Rezoning Transportation Analysis

Petition Number: 2021-169

Reviewer: Kevin Parker, PE
Kevin.Parker@charlottenc.gov
704-432-6511

Date	Description
11-19-2021	First Review (KP)
12-20-2021	Second Review (KP)
01-27-2022	Third Review (KP)

JOB NO.	99999
SHEET NO.	RZ-100

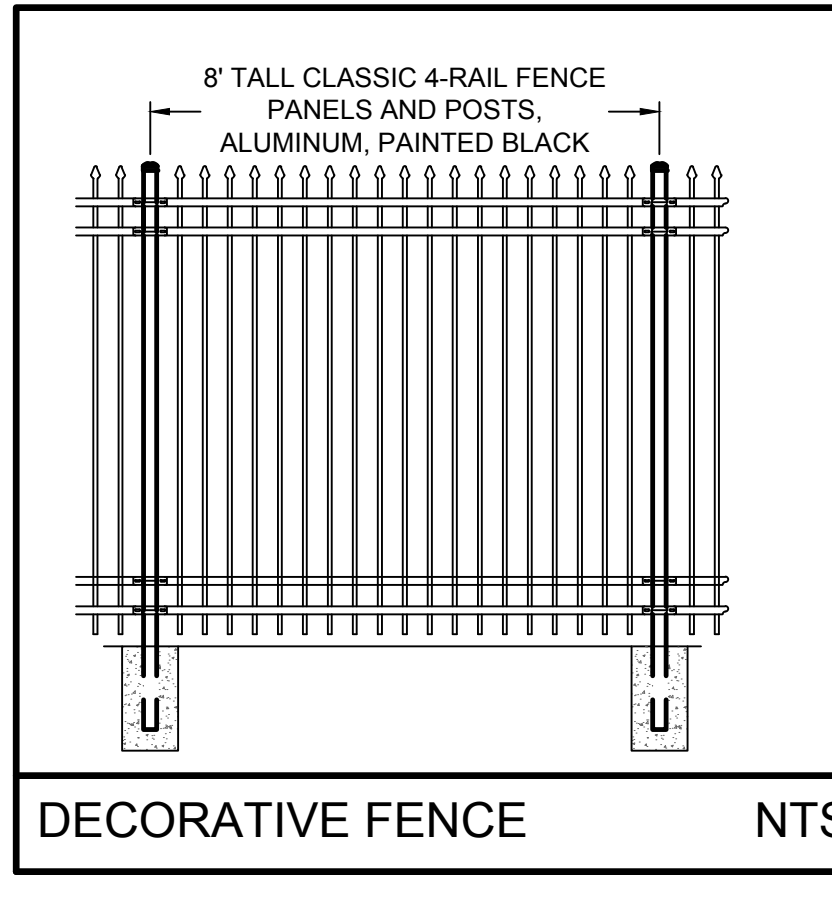
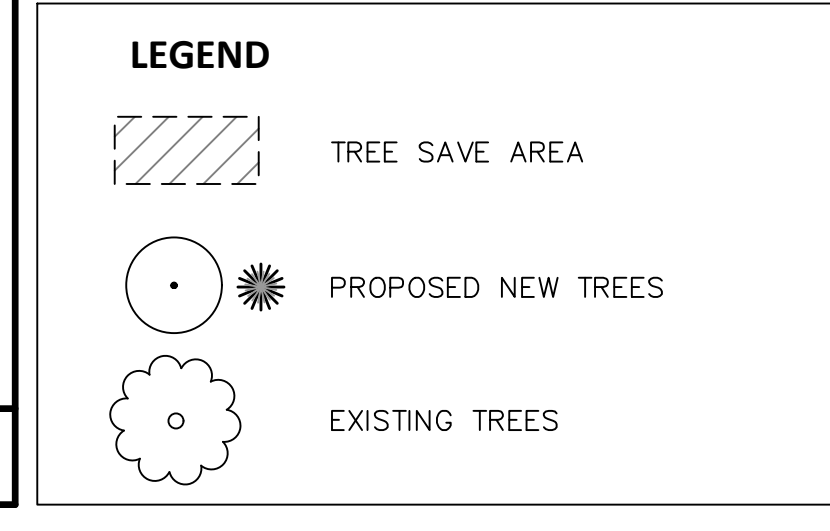
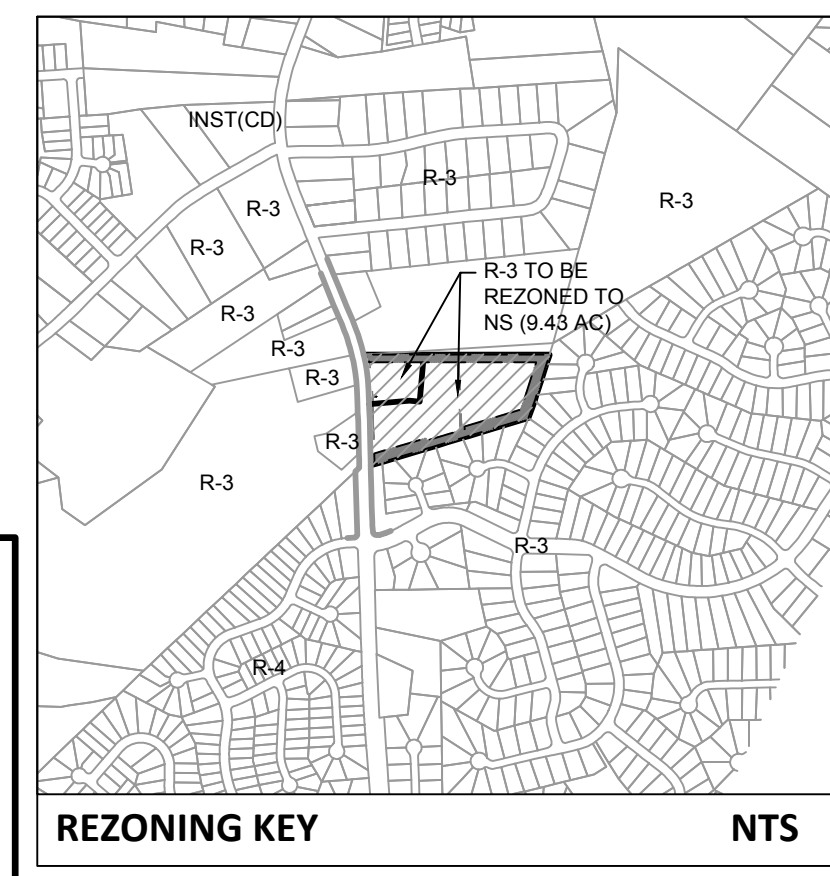
3. Revise site plan and conditional note(s) to commit to dedicate 52-feet of right-of-way from the existing centerline of Mount Holly-Huntersville Road. The site plan shall label and dimension the right-of-way from the road centerline.
